Please upload the email below which is a further consultation response from **ADC Drainage Engineers** to discharge of condition application **LU/90/20/DOC** – Hampton Park.

Paul Cann
Principal Engineer (Drainage)

© This drawing and the building works depicted are the copyright of Banners Gate Ltd and may not be reproduced or amended except by written permission. No liability will be accepted for amendments made by other persons.

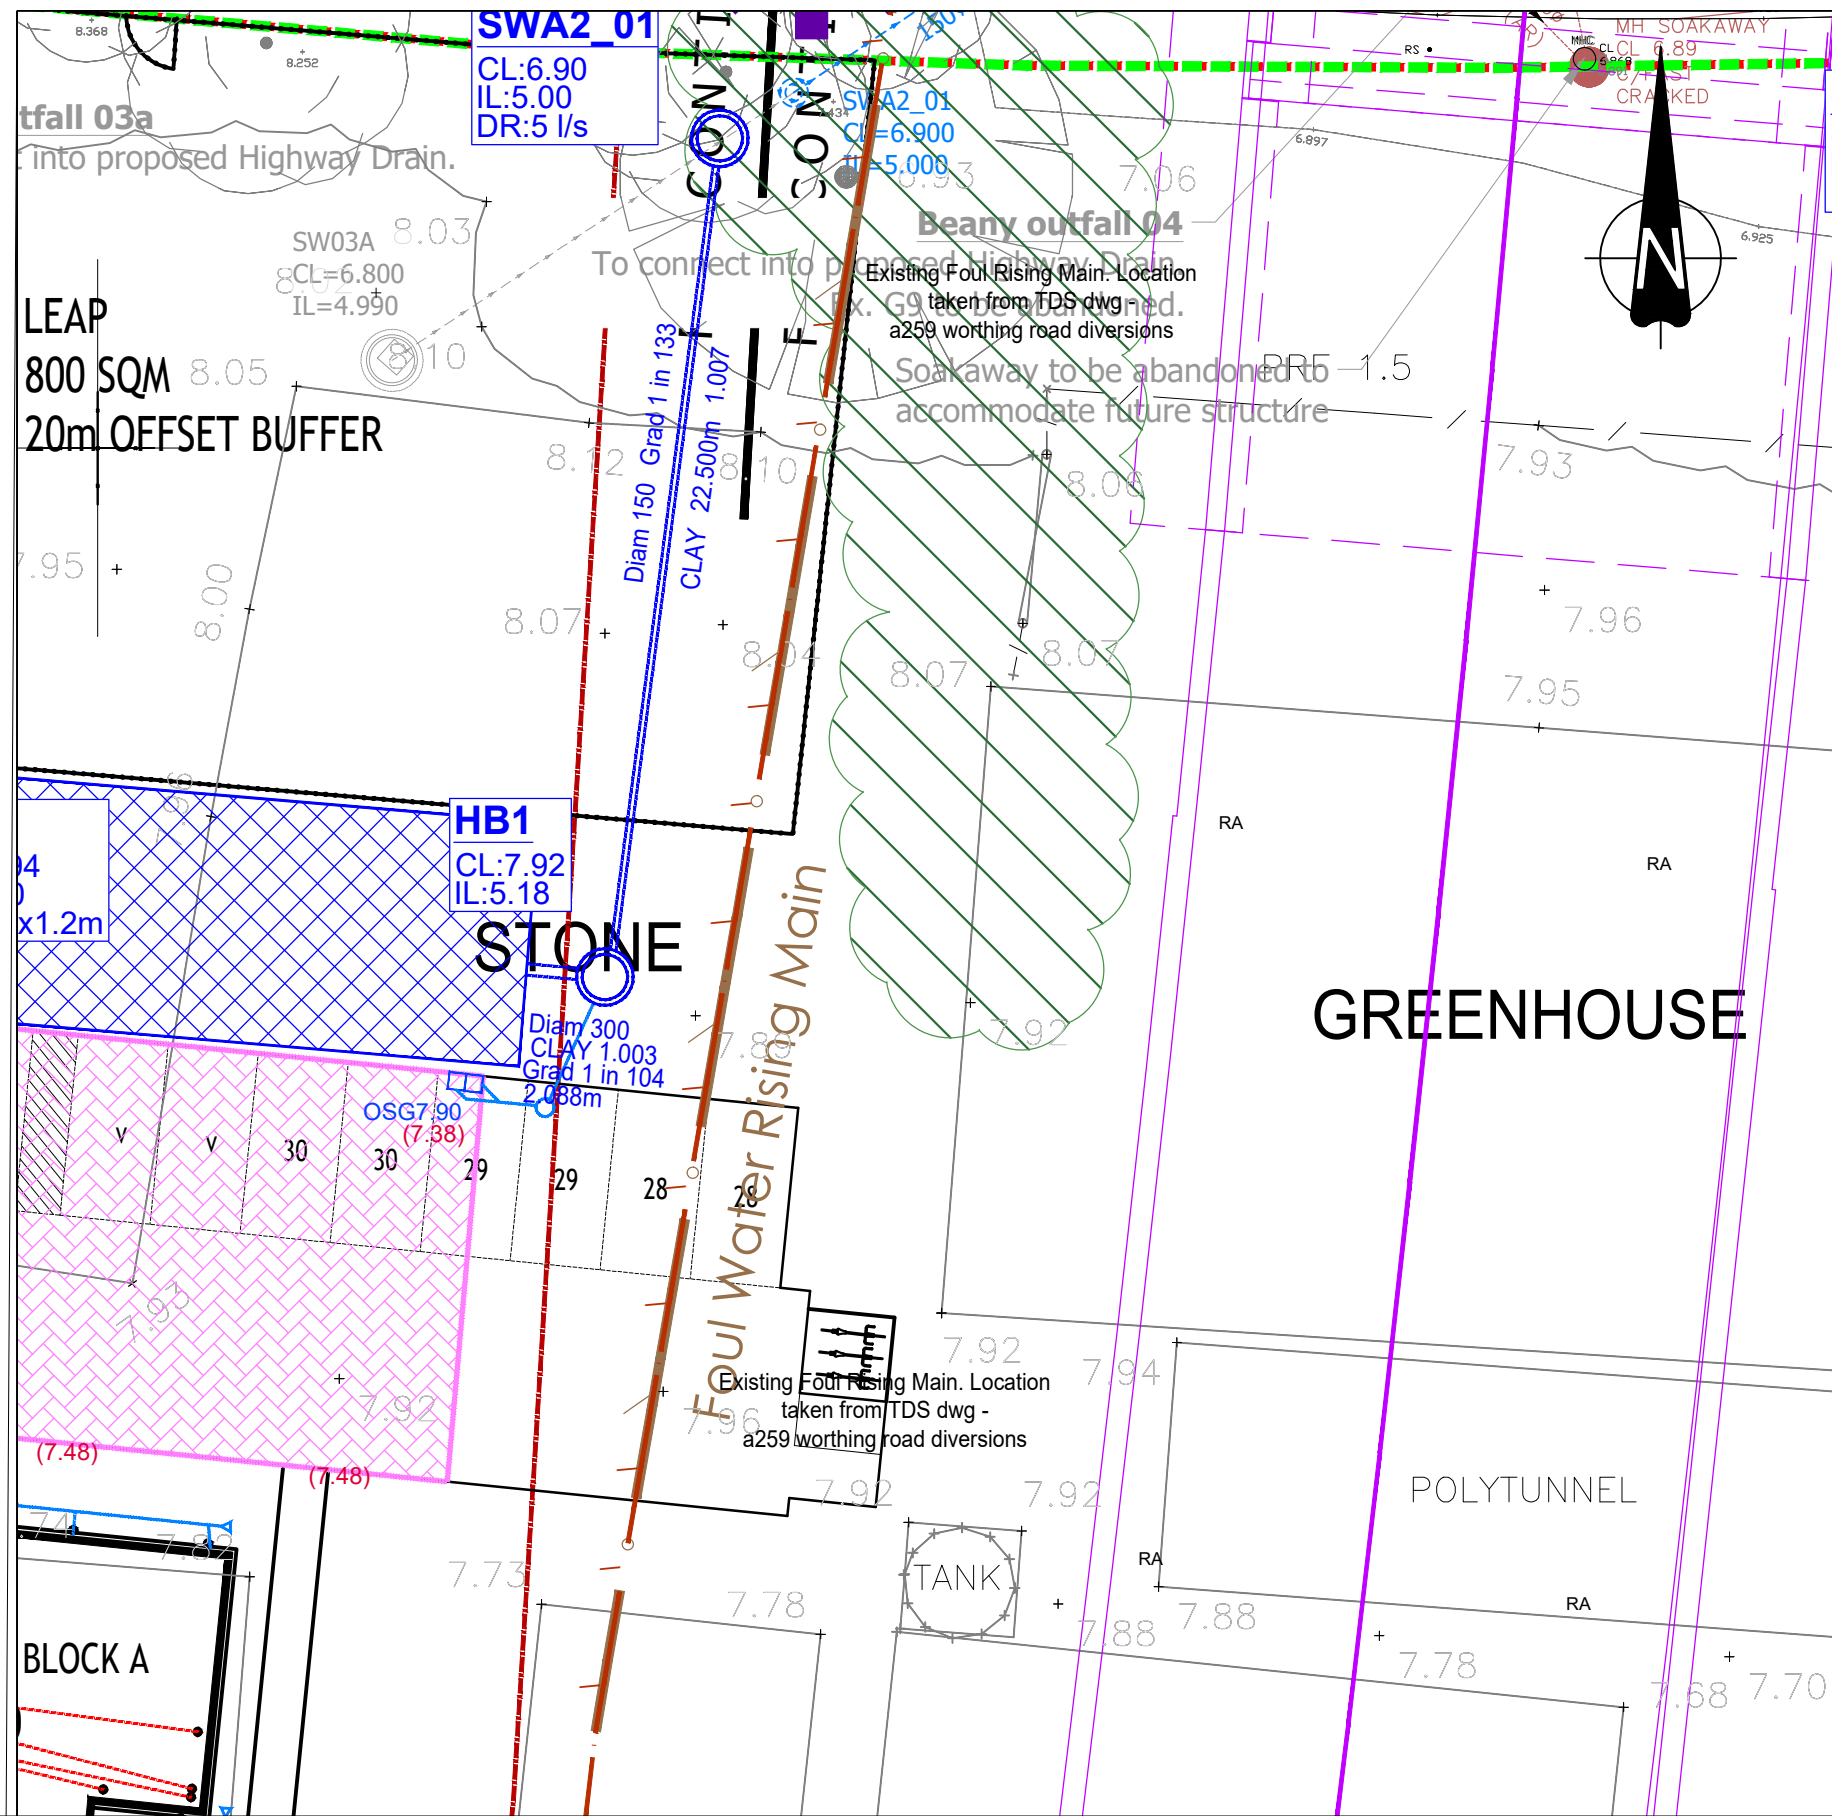
3. Provide channel drain construction details/spec.
4. Hydrobrake chamber HB01 construction detail – connect incoming 150mm connection from permeable paving at soffit to soffit level with 300mm pipe inlet.

6. Both hydrobrake chambers – show base thickness/reinforcement details.
7. Existing manhole SW03A – just upstream of SWA2_01 – what is its purpose? Invert level is lower than the downstream manhole. Please clarify if it is required and adjust as necessary.

Hydro-Brake Control Chamber HB2

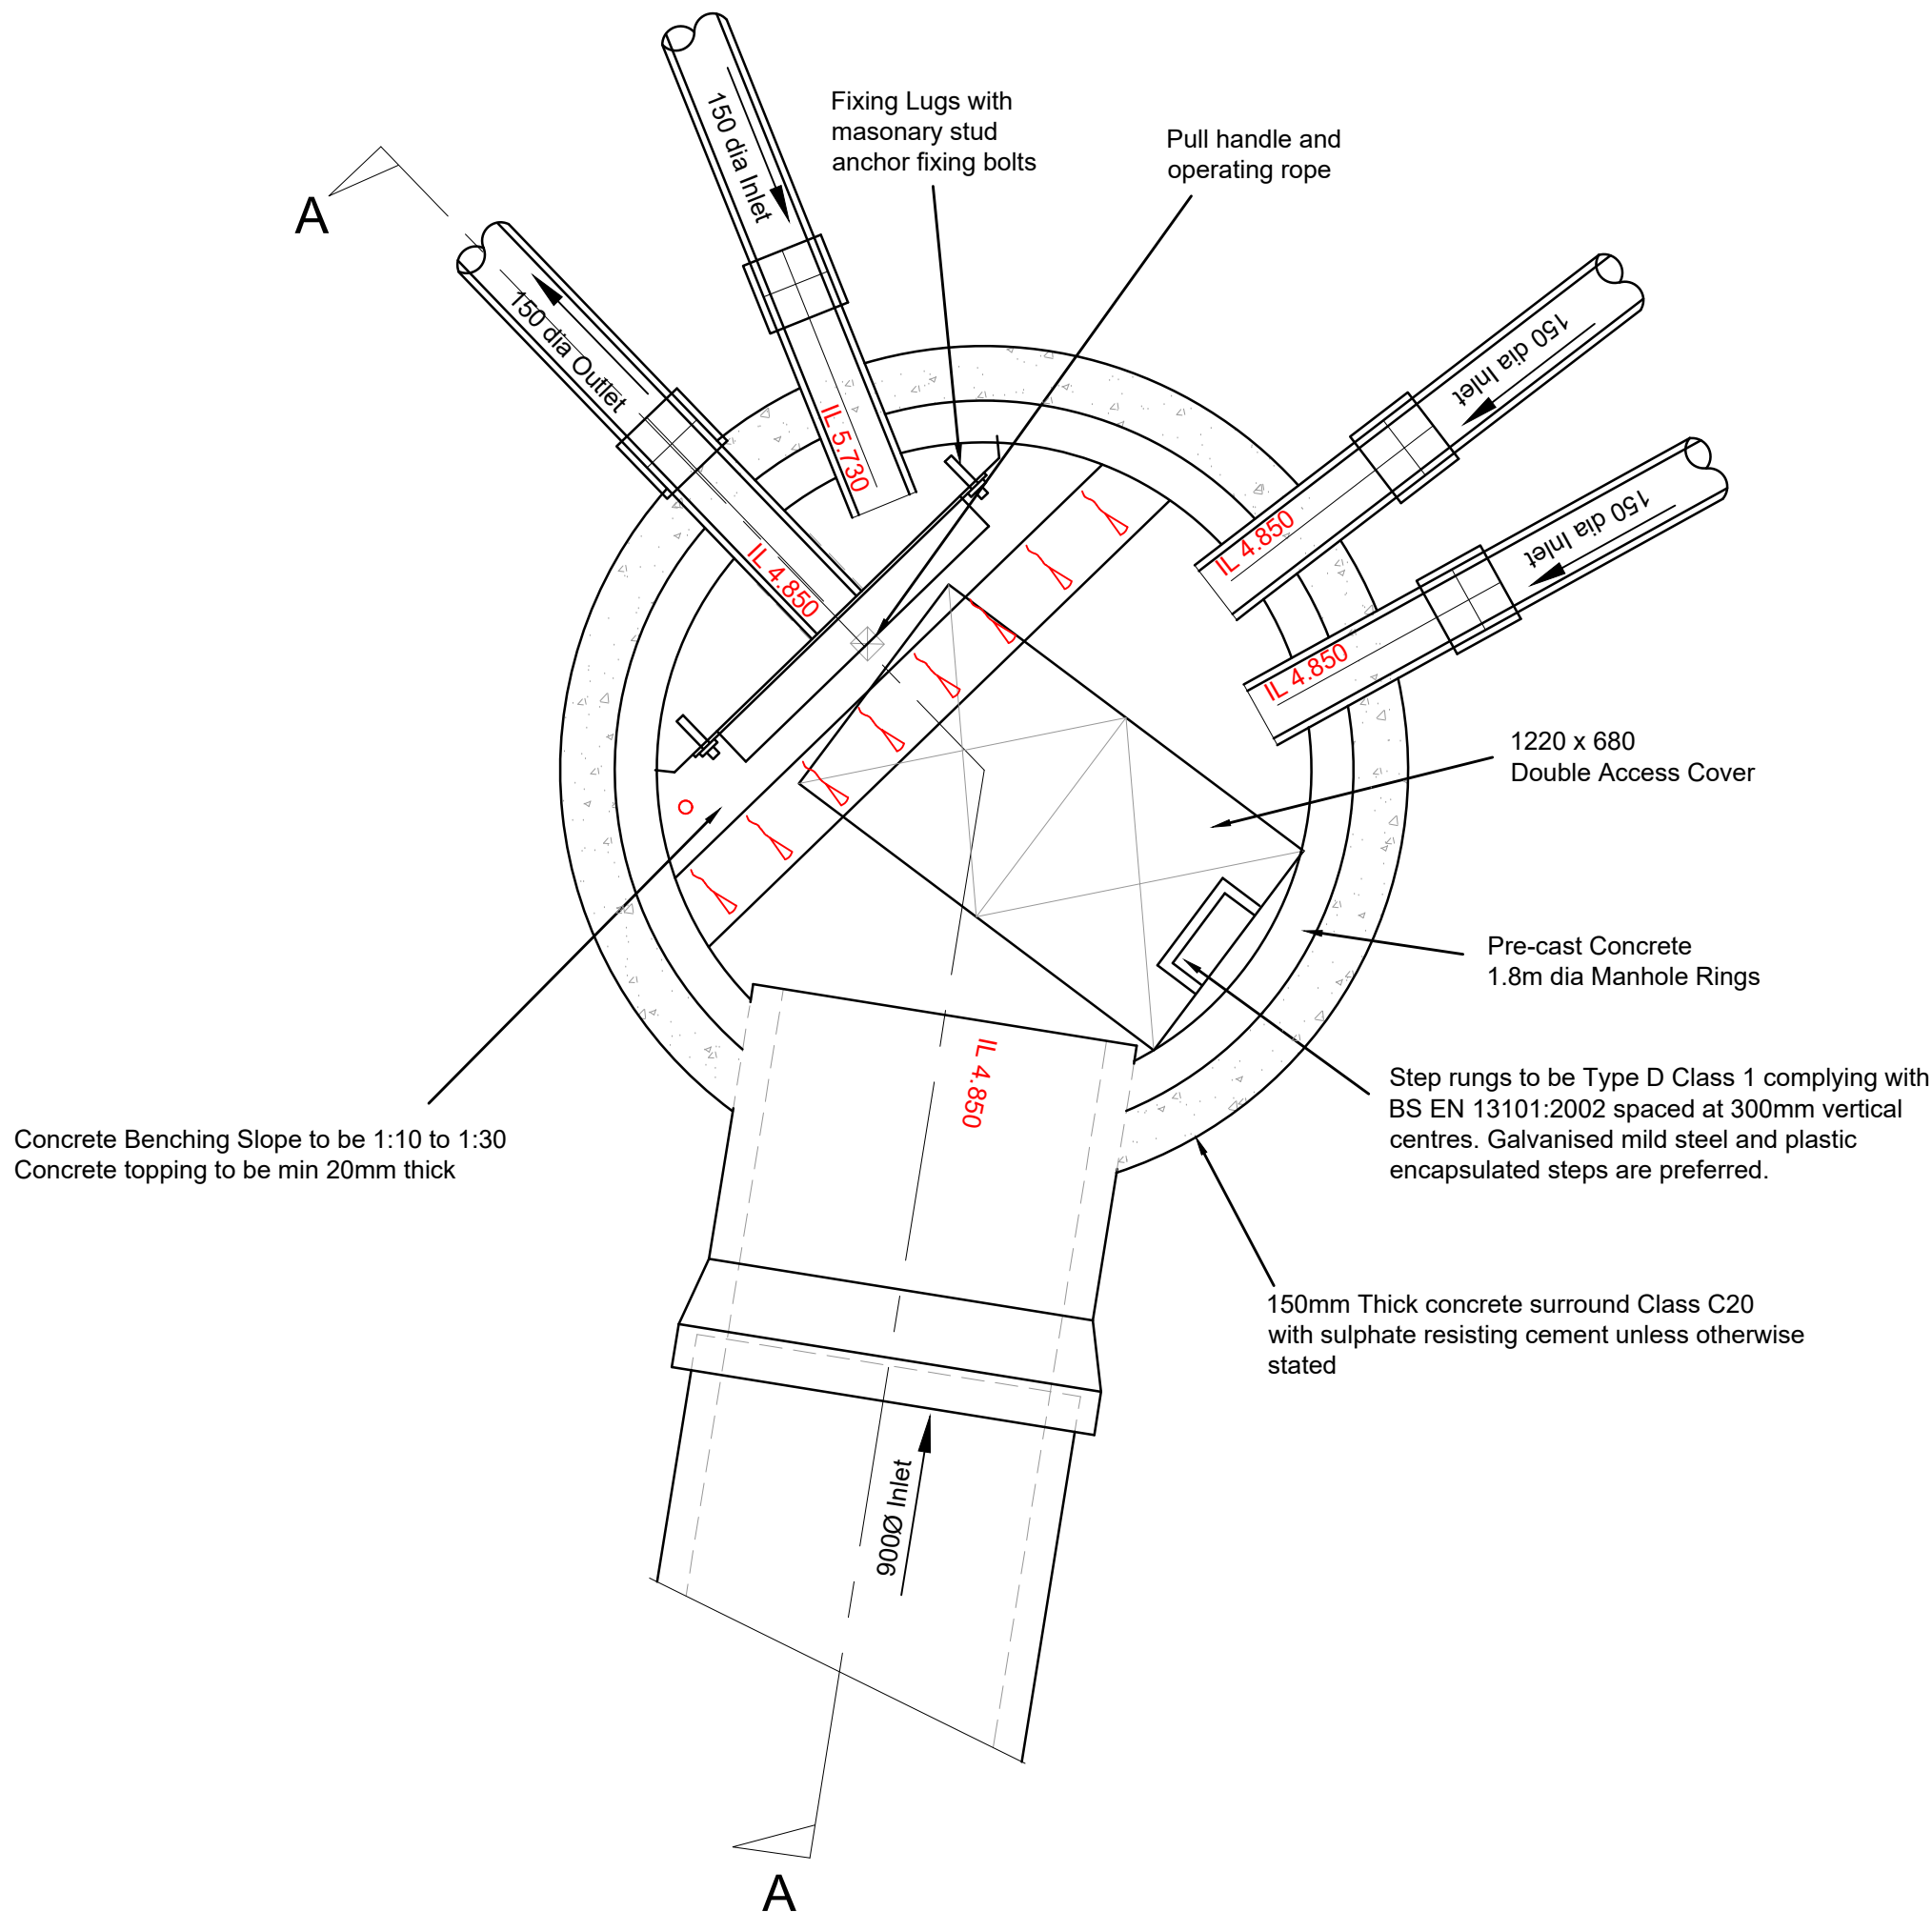
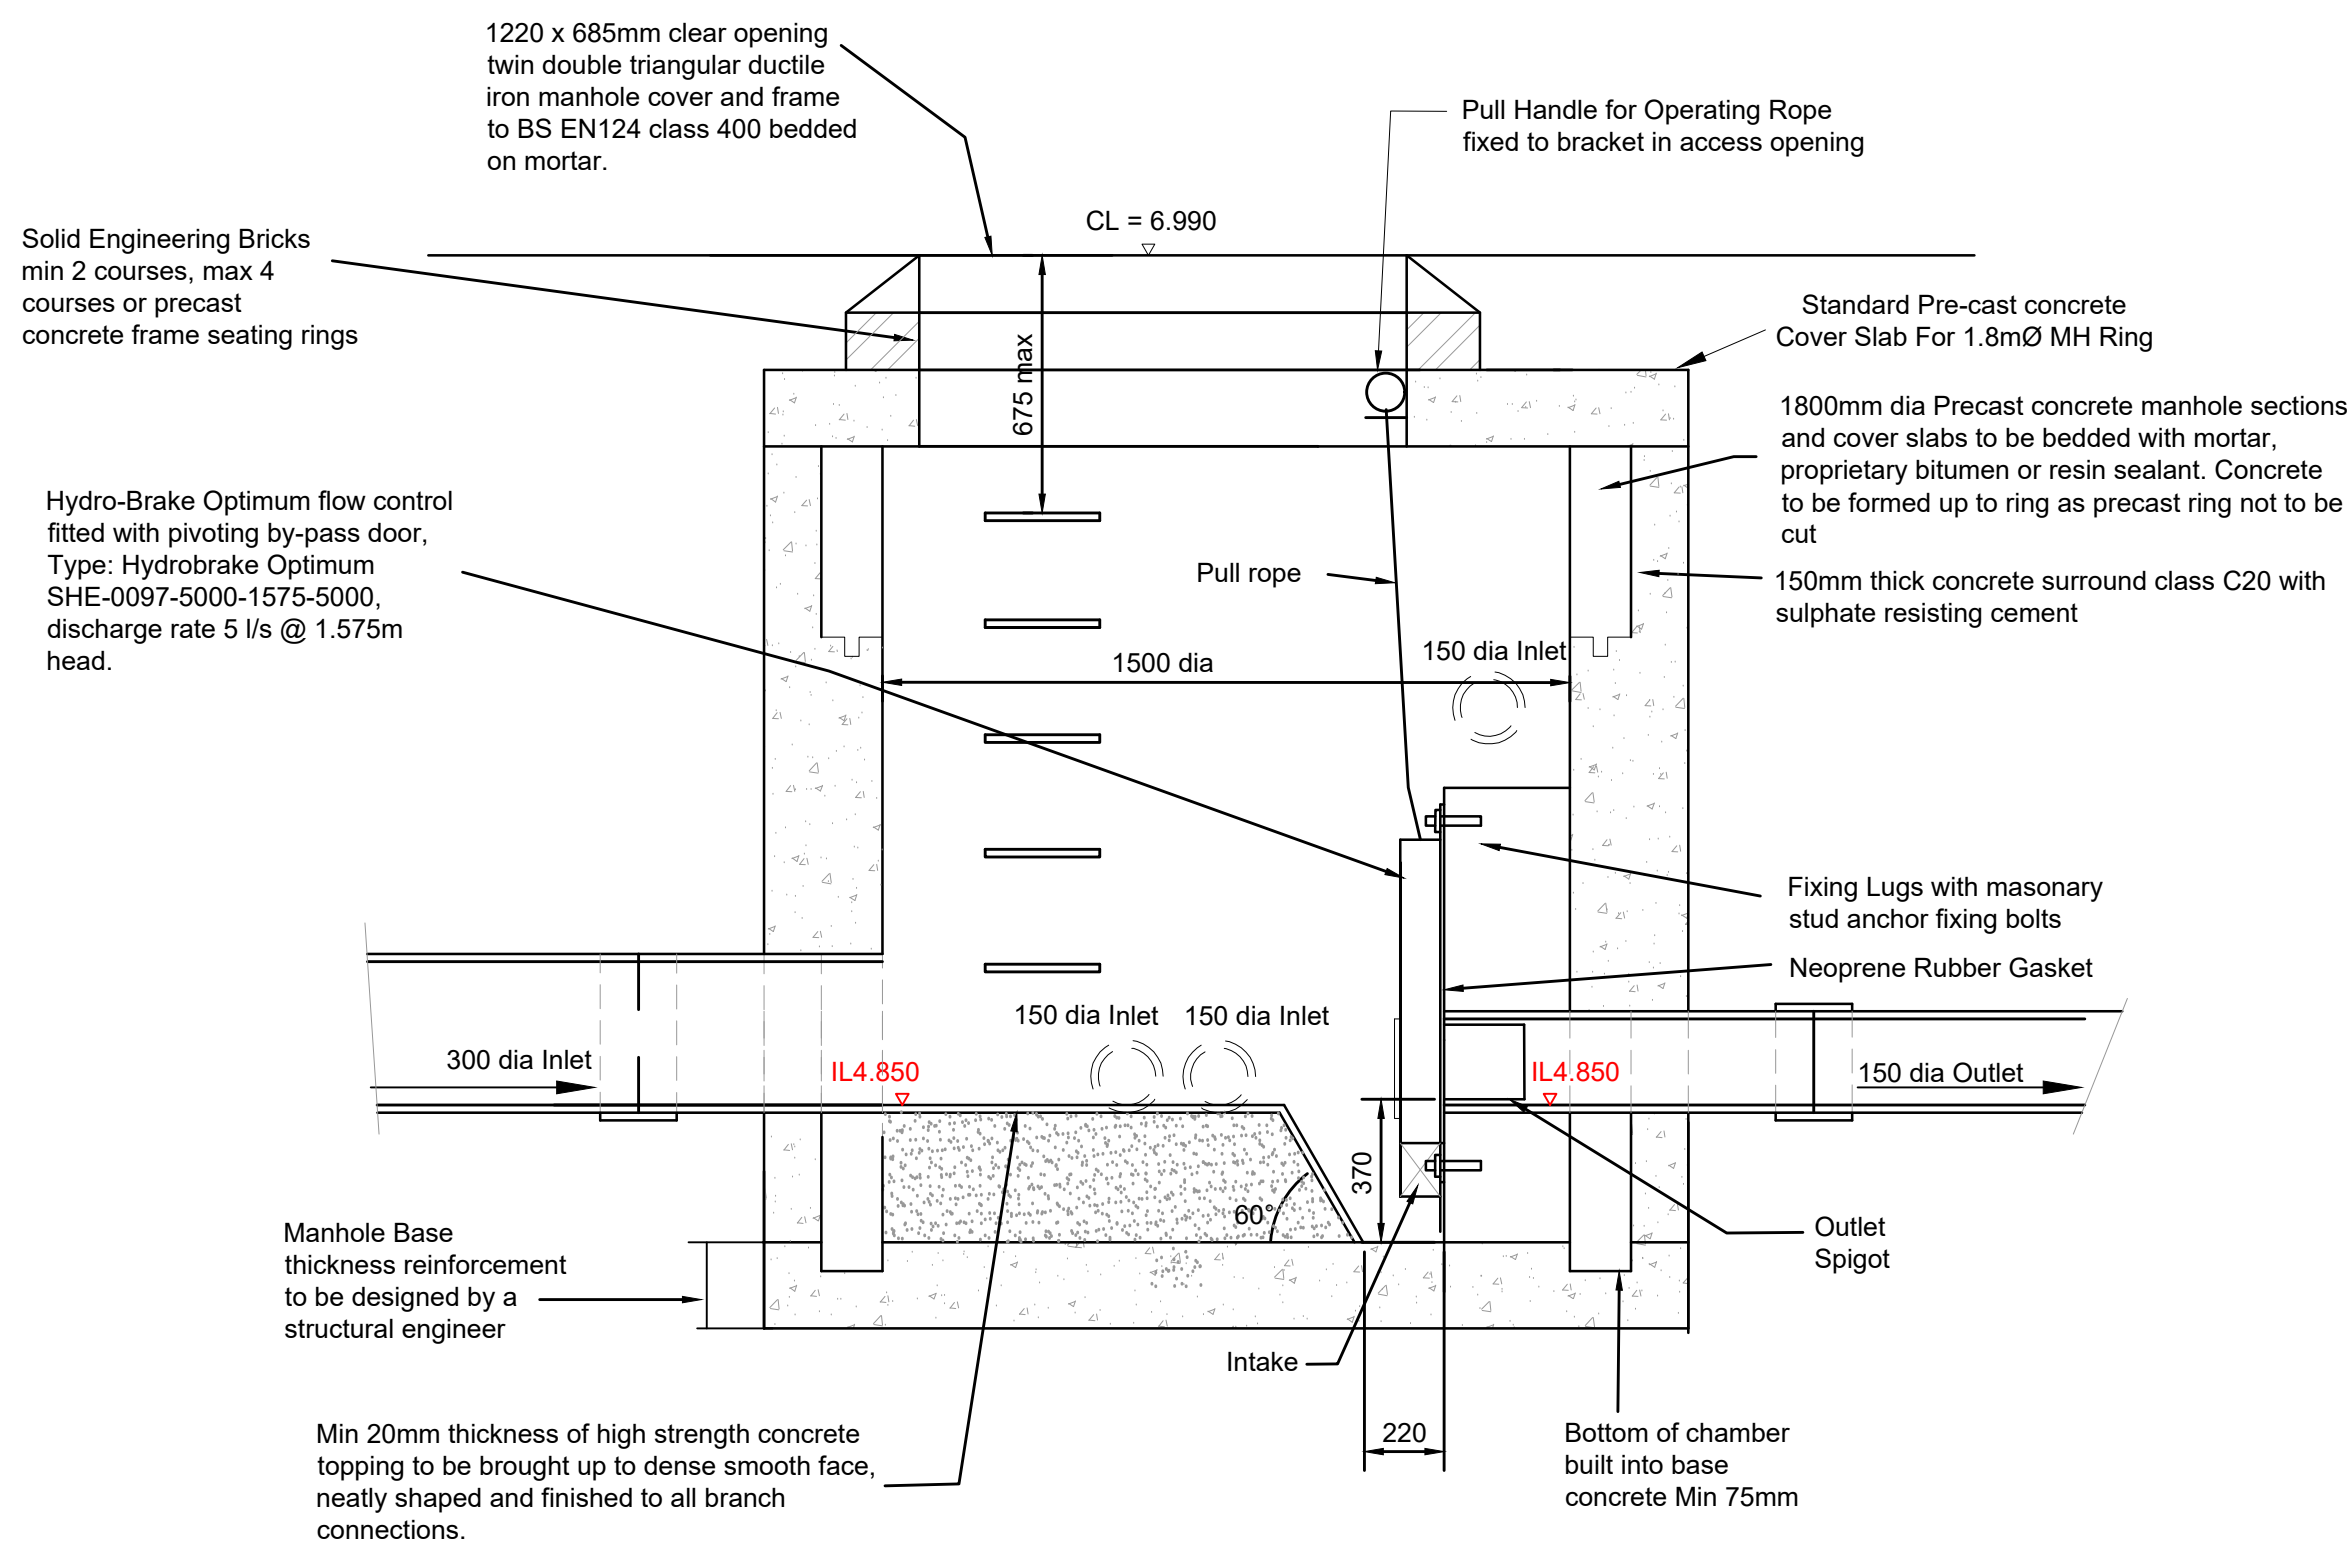
5. Hydrobrake chamber HB02 construction detail – plan view shows incoming 900mm pipe as opposed to 300mm and 1.8m dia rings as opposed to 1.5 dia. Incoming 150mm connections to connect soffit to soffit with 300mm pipe. The gully that is connecting against flow and above hydrobrake is not ideal but willing to accept it in this instance (Section A-A shows it in a different location to the plan view?)
